From: Patel, Uday <Uday.Patel@lancashire.gov.uk>
Sent: 05 August 2014 10:53
To: planning
Cc: ENV LHS Customer Service
Subject: 3/2014/0613 - Outline planning application to construct 2 no detached houses - Land at Chapel Close Low Moor Clitheroe BB7 2QT

Planning Application Reference: 3/2014/0613

Proposal: Outline planning application to construct 2 no detached houses

Location: Land at Chapel Close Low Moor Clitheroe BB7 2QT

Description
EXISTING SITE PLAN

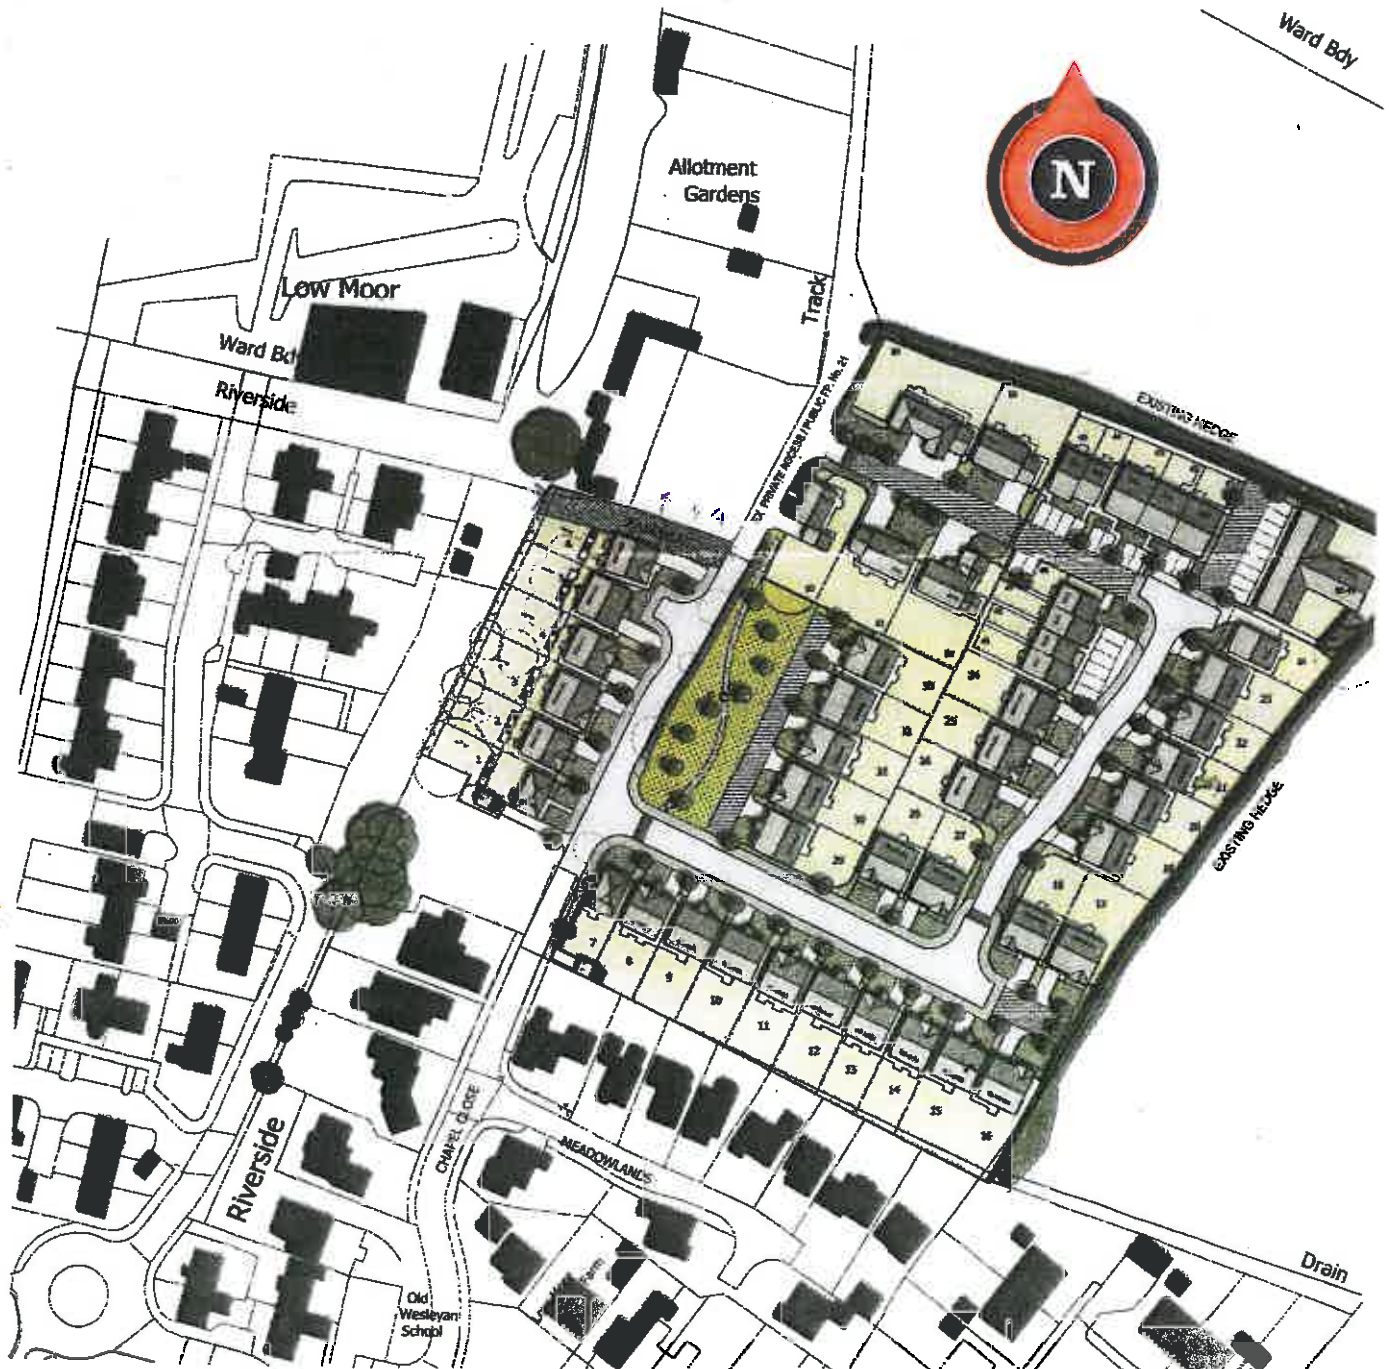
Proposed site is adjacent to existing Public Rights of Way FP21. There are other residential development near the site which are accessible from PROW FP21. Width of existing public rights of way FP21 in front of the property is approximately 5.5m. It is believed that due to existing development along FP21, there is vehicular movement on FP21.

Shared access from existing PROW FP21 to both the properties will be considered appropriate. Detailed design in terms of layout/ parking provision/access details including visibility splay/ position of gates if any shall be required to evaluate the proposal accordingly.
